**Addendum No. 1**

RE: Contract ID: C202046

**Randolph County (B-4613)**

Bridge Over Fork Creek and Approaches on SR-2873

ENGLISH DETAIL DRAWING FOR
BRIDGE APPROACH FILLS
SUB REGIONAL TIER

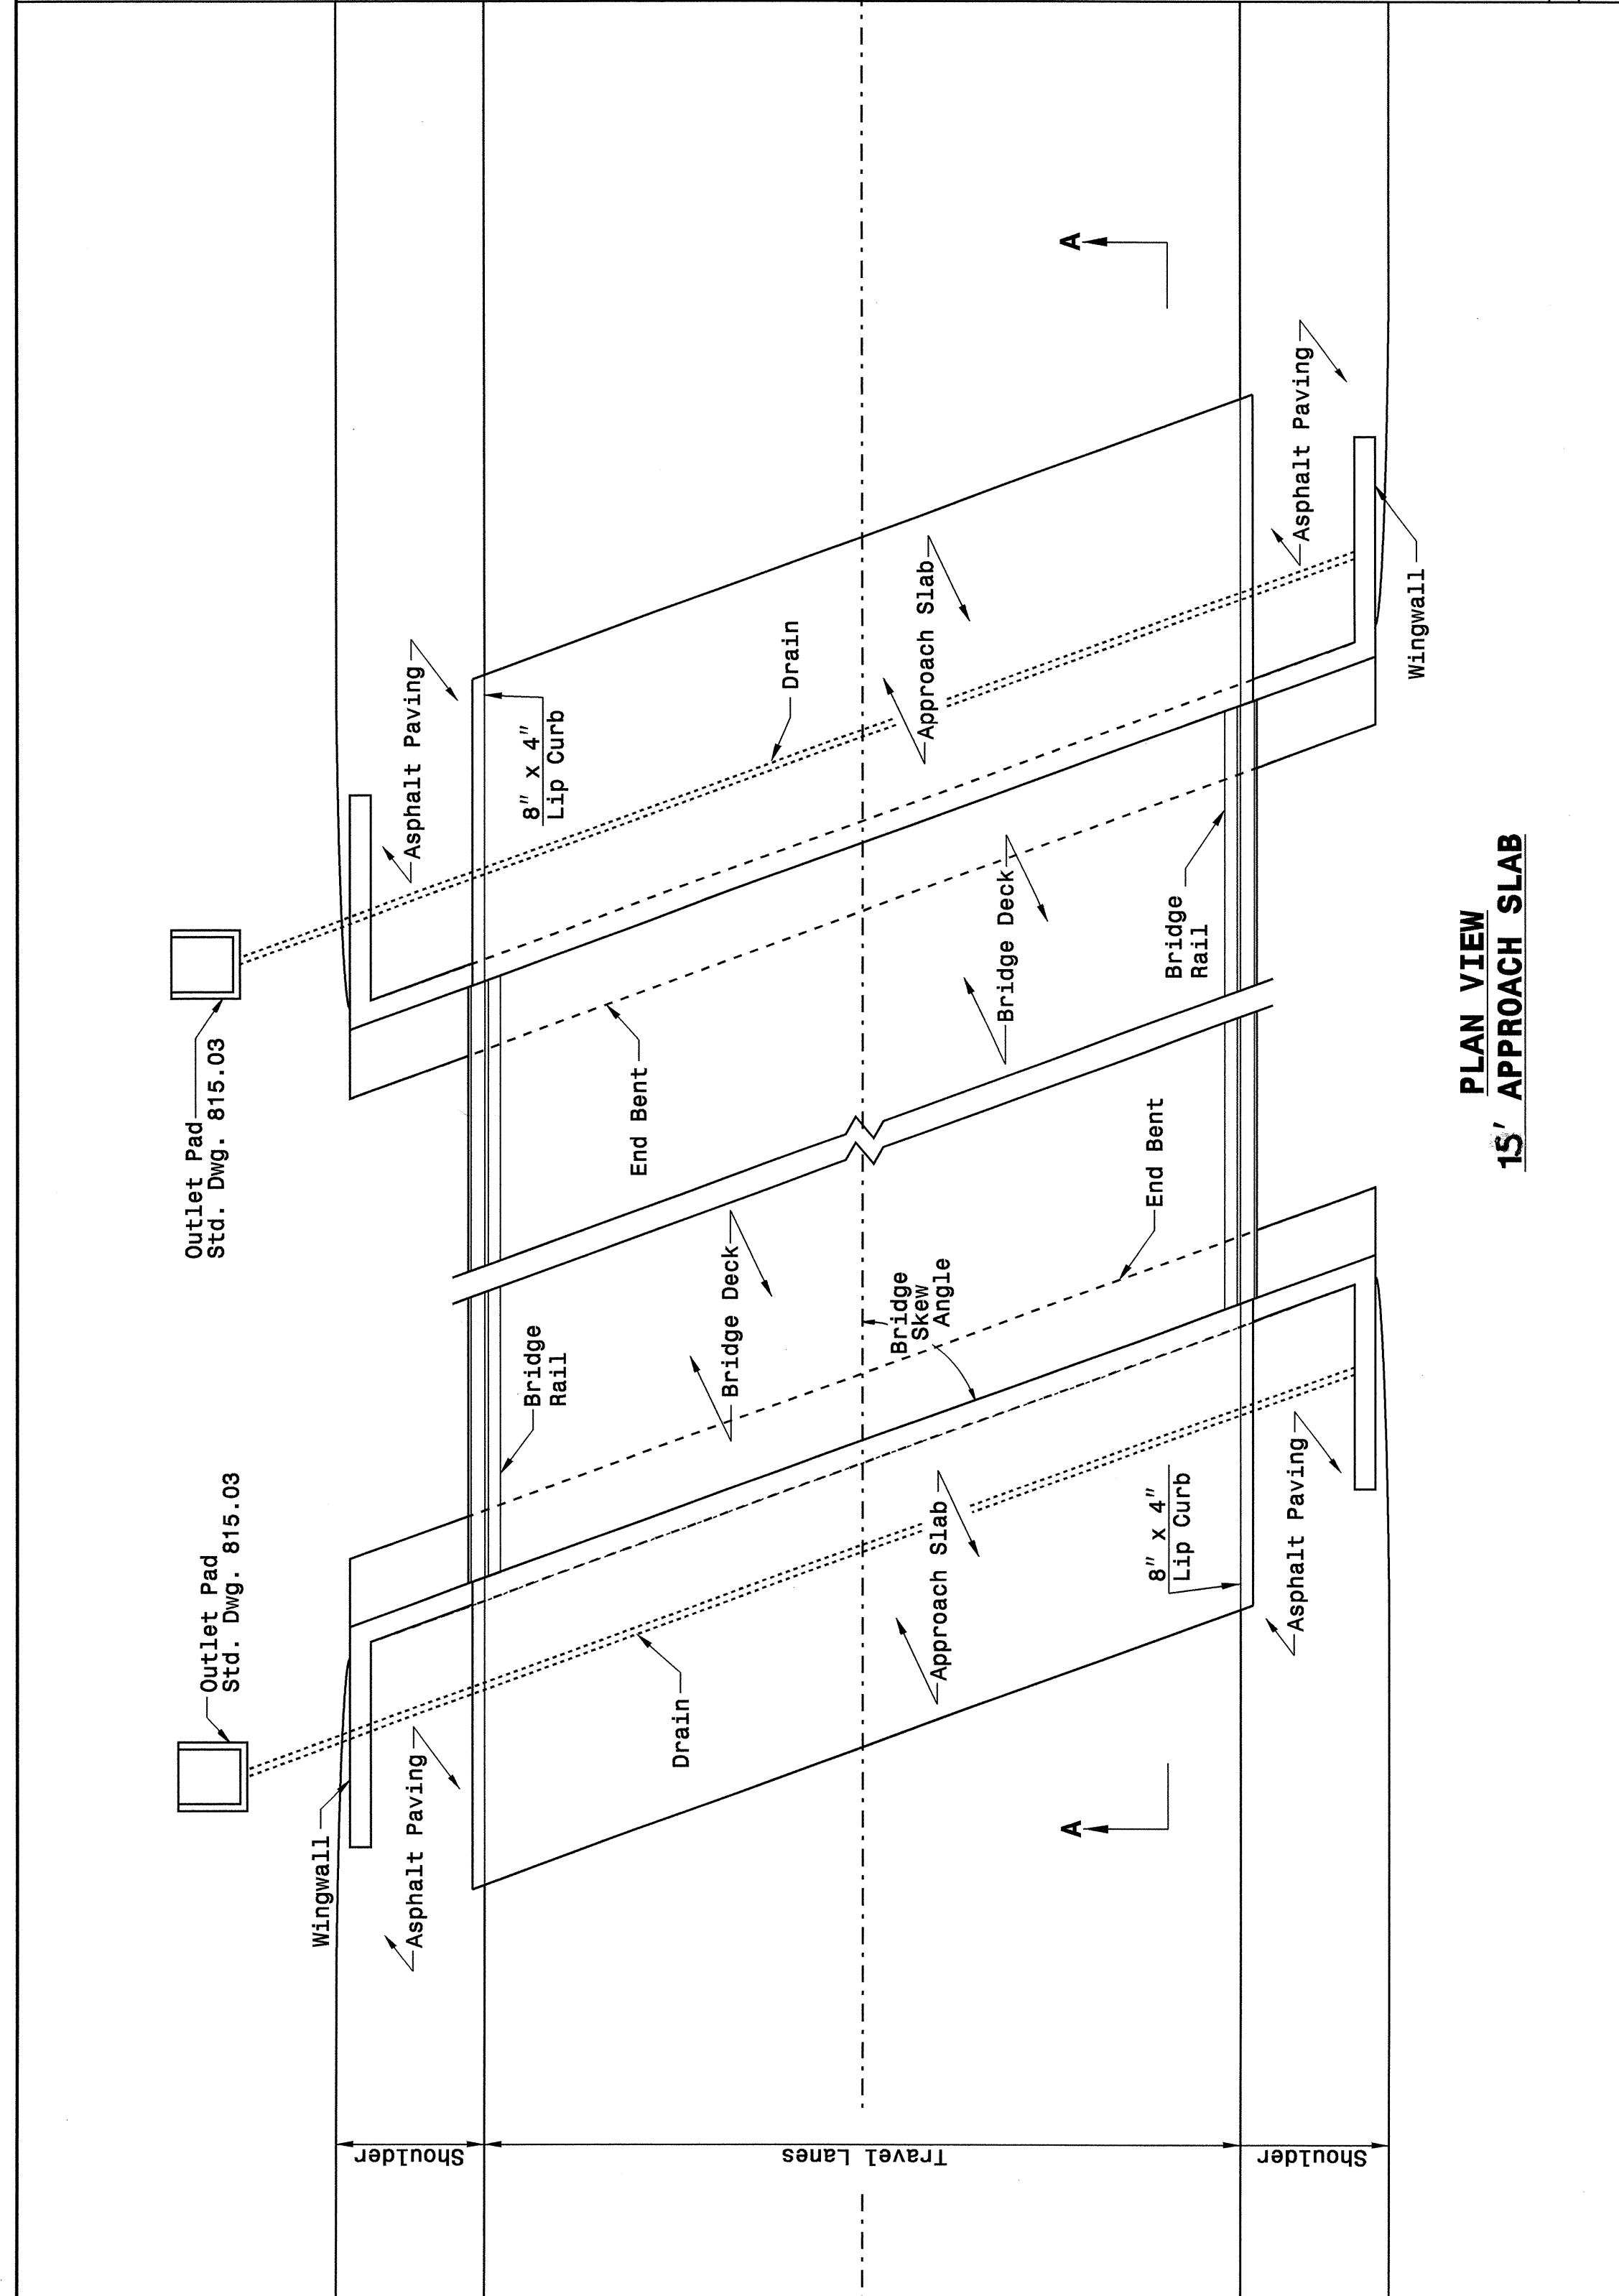
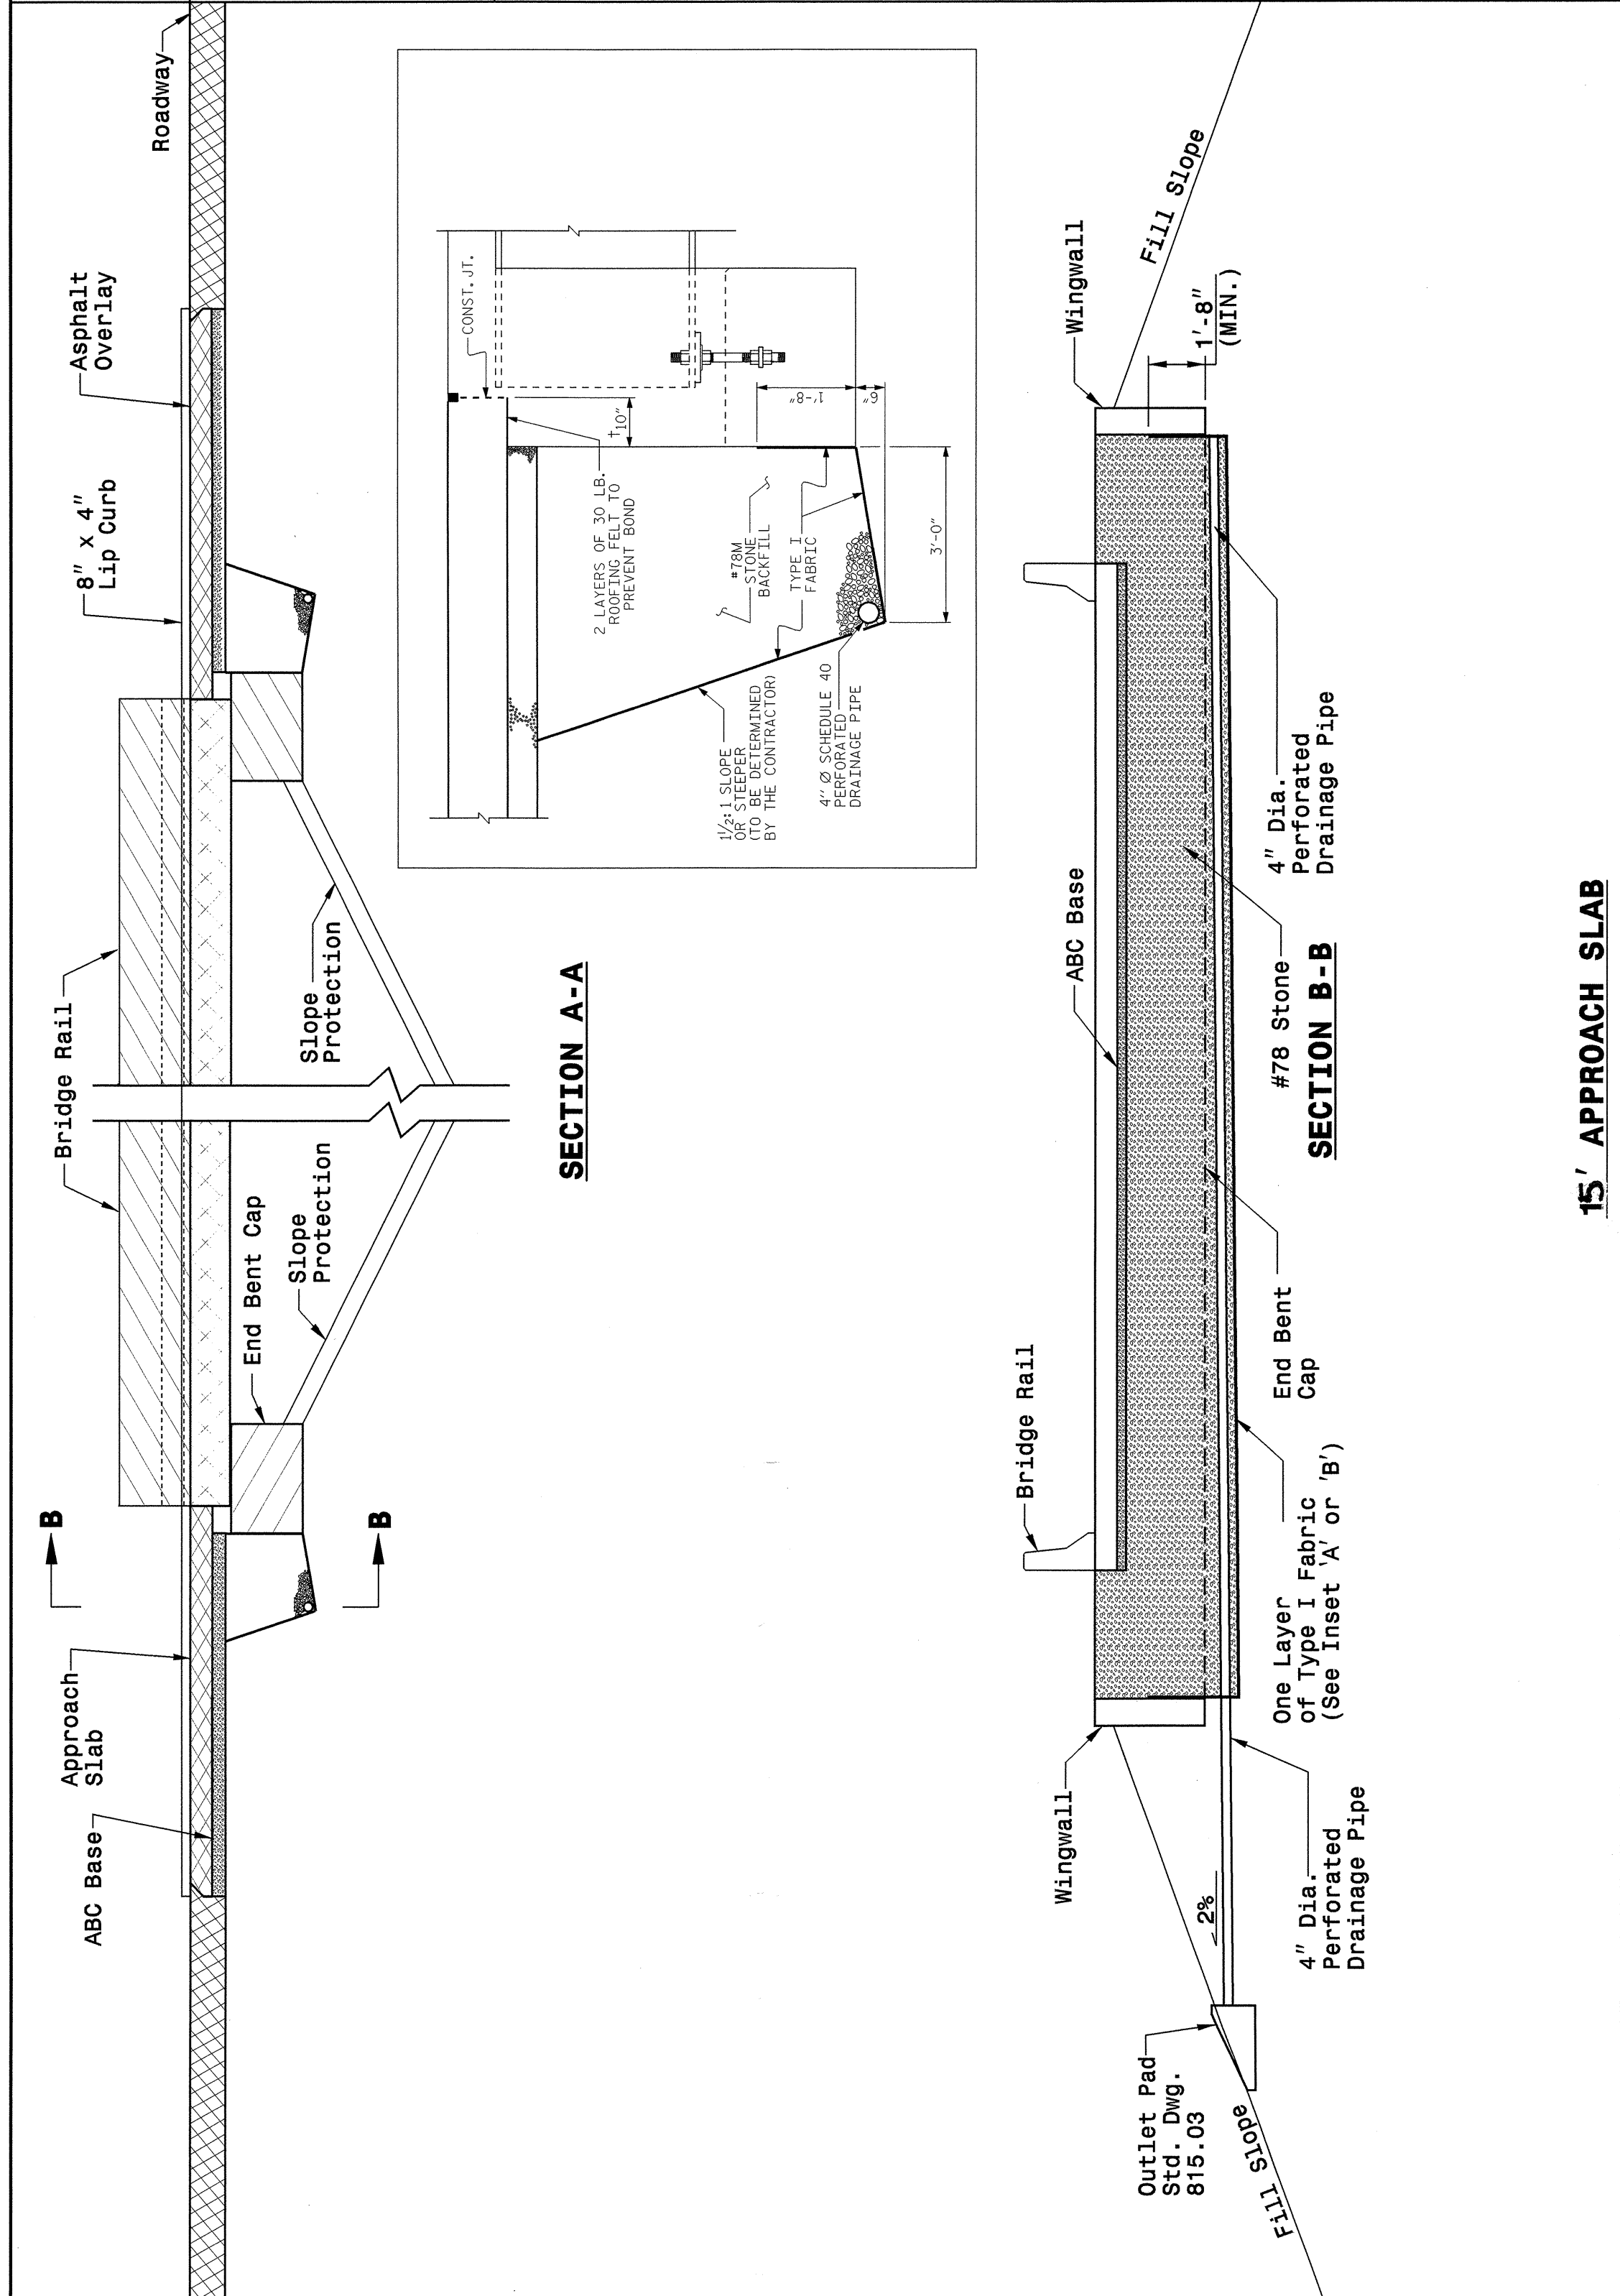
On Sheet No.1-A the Index of Sheets has been revised to add Sheet No.2-B. Please void Sheet No.1-A in your plans and staple the revised Sheet No. 1-A thereto. New detail Sheet No.2-B "Bridge Approach Fill Sub-Regional Tier" has been added. Please staple new detail Sheet No.2-B after Sheet No. 2-A in your plans.
